CITY OF PORTLAND, MAINE

PLANNING BOARD

March 9, 2005

RE: 56 Wilson Street
CBL: 003 N009001

SITE/SUBDIVISION PLAN
OF:
WILSON HEIGHTS CONDOMINIUMS
11A BARTLETT ROAD
GORHAM, ME 04038

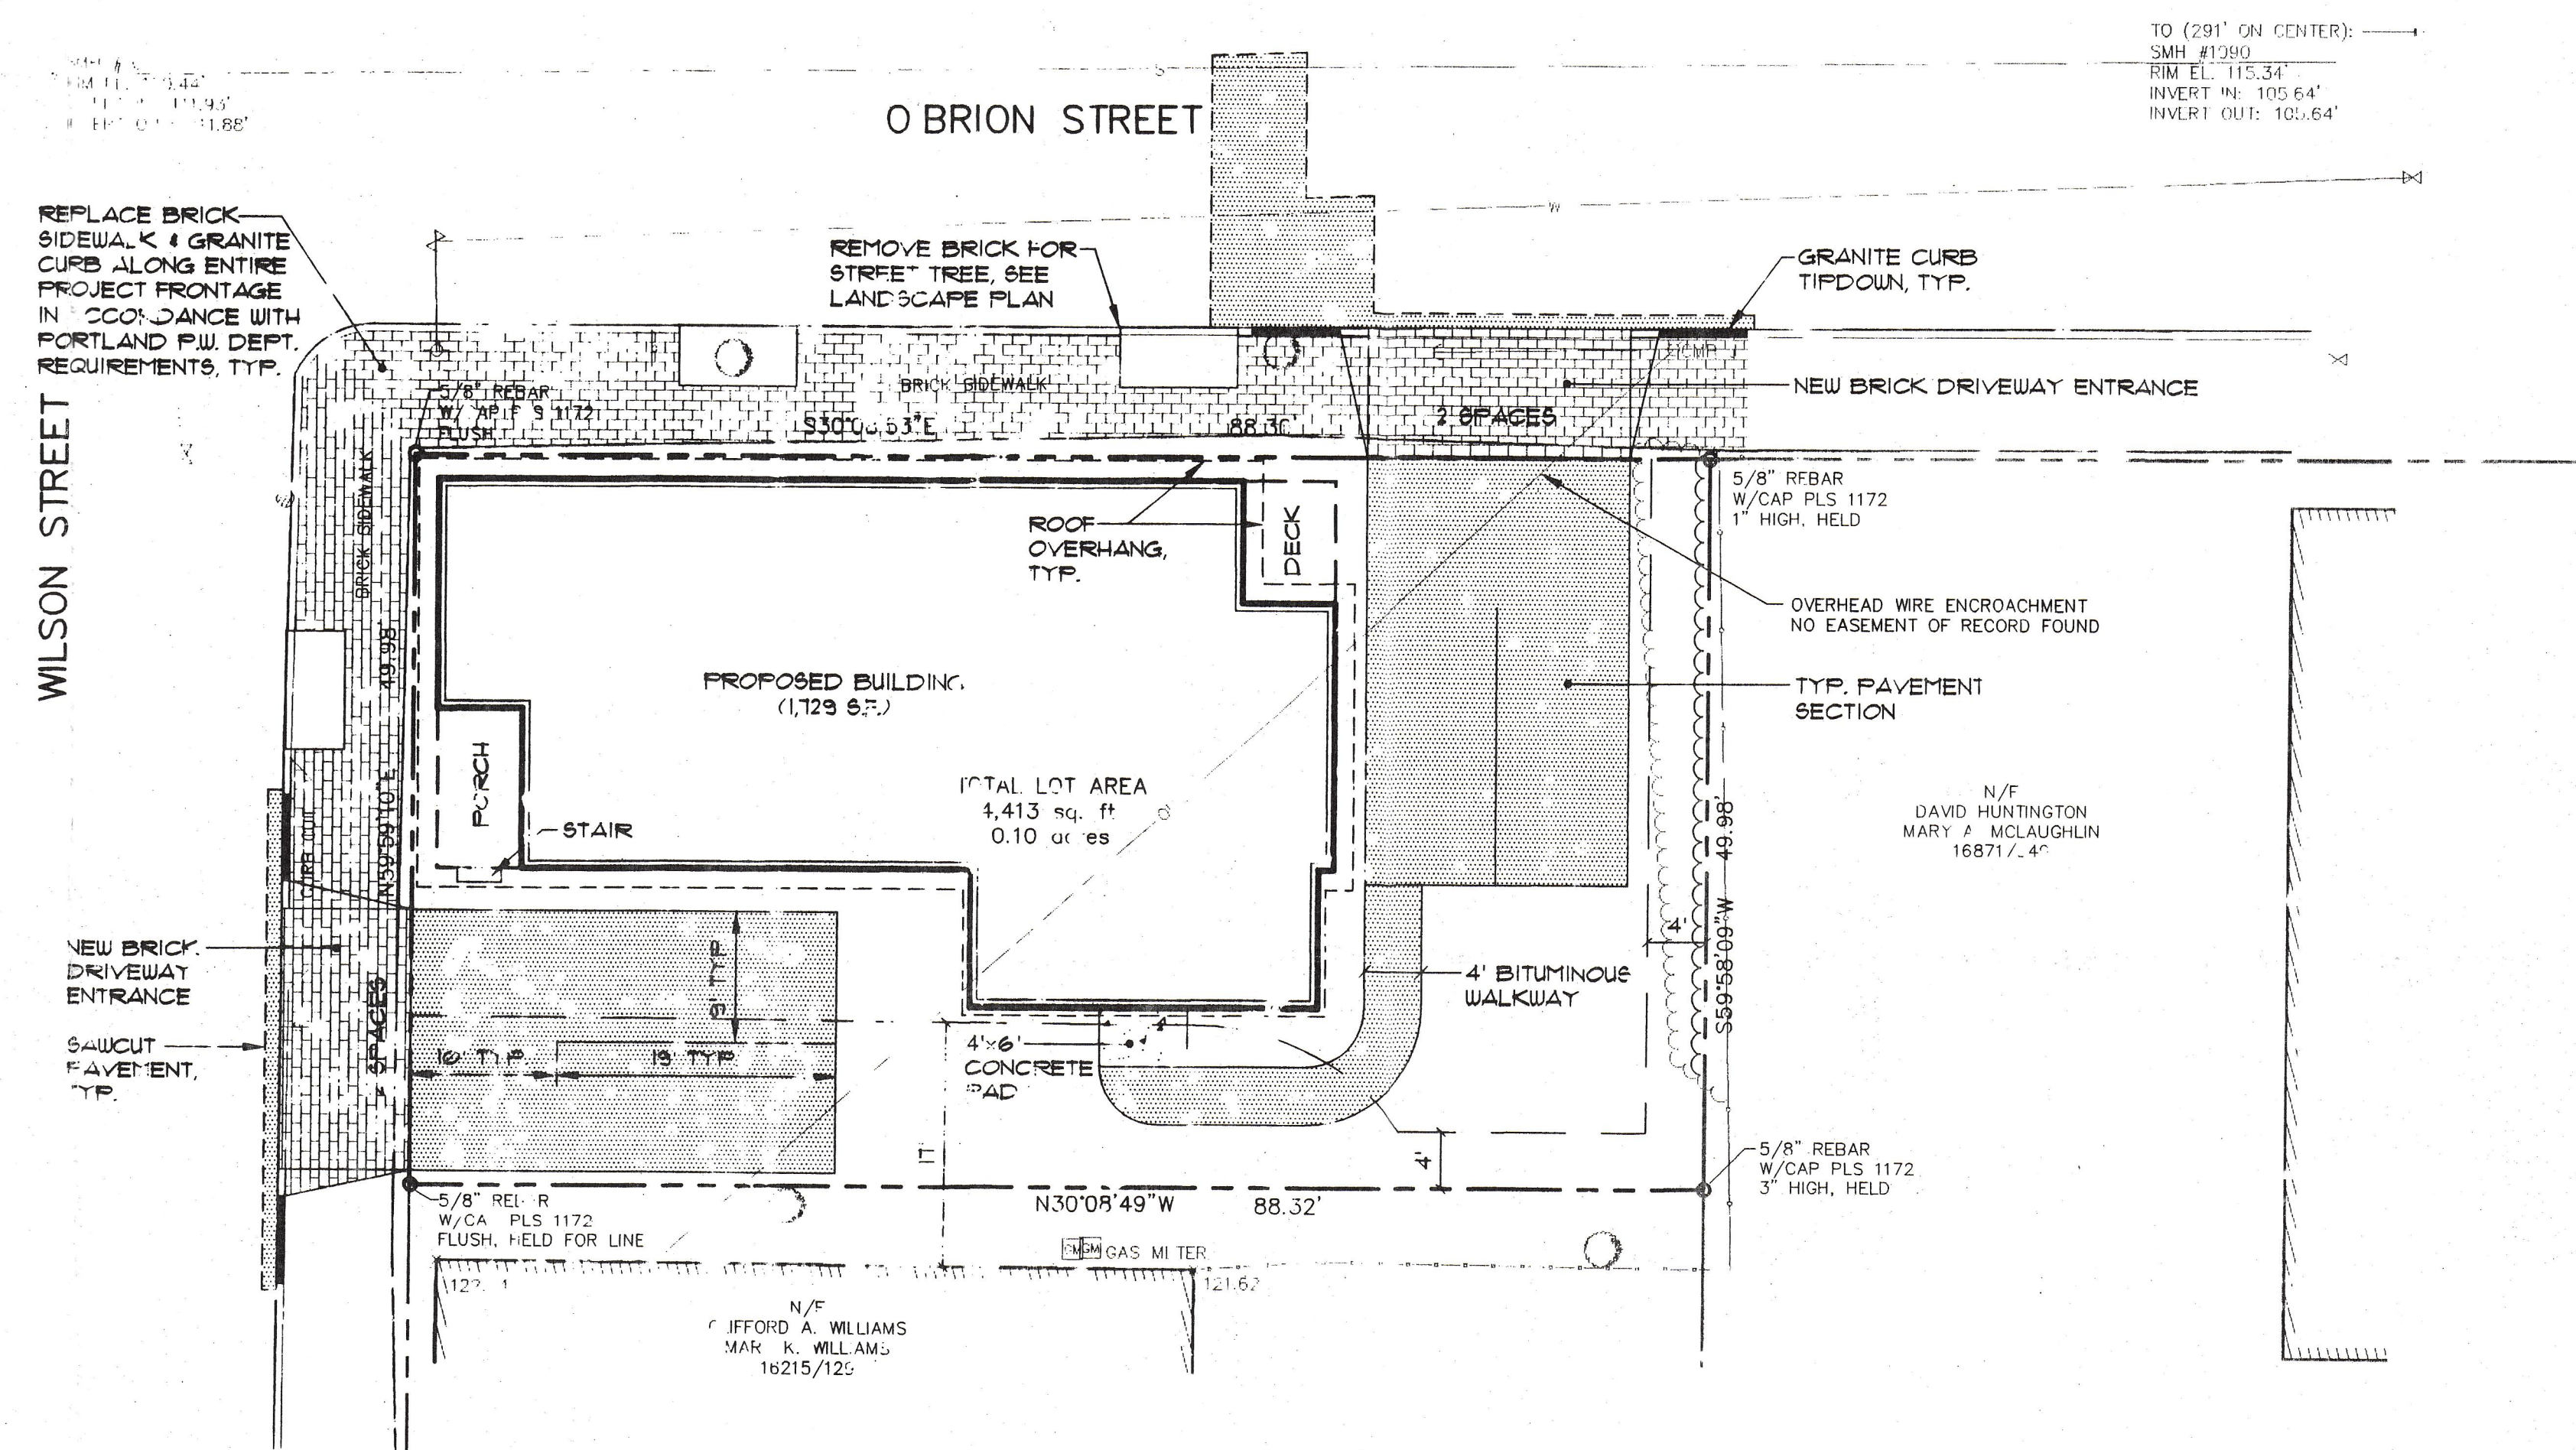
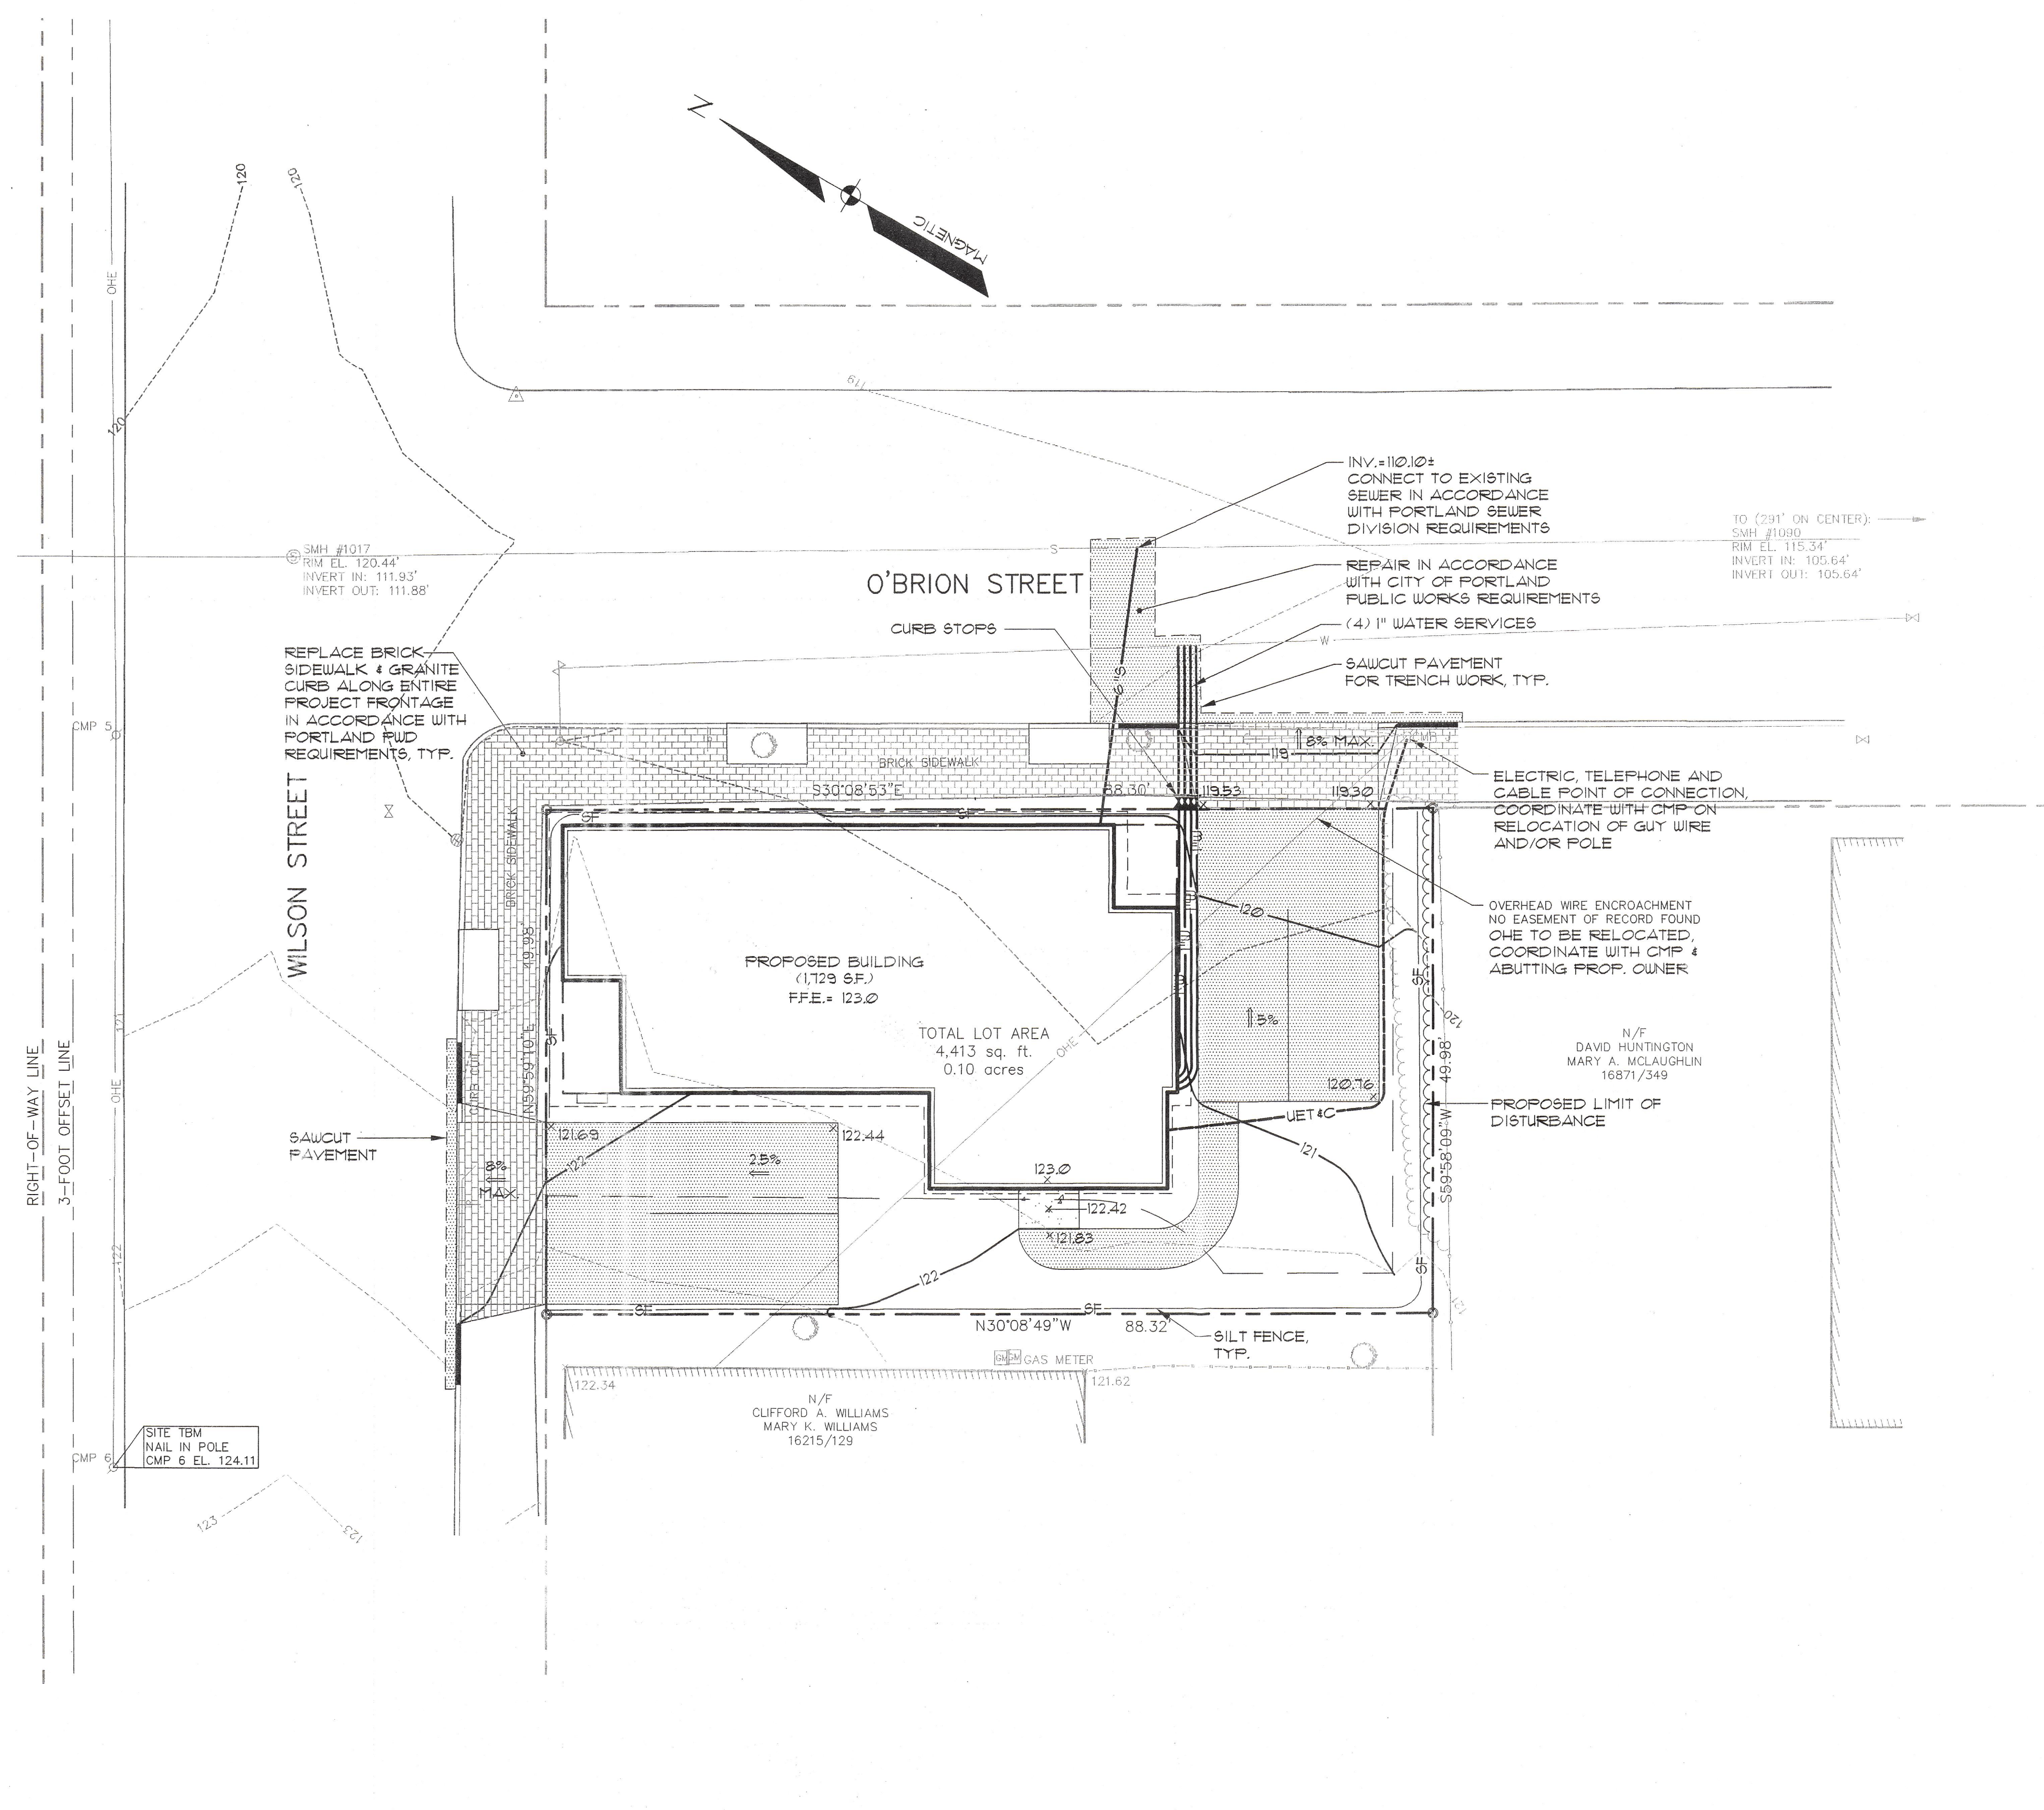
- That the plans be amended to indicate the full replacement of brick sidewalk and granite curb along the O'Brien frontages of the site in conformance with the City of Portland Technical Standards.
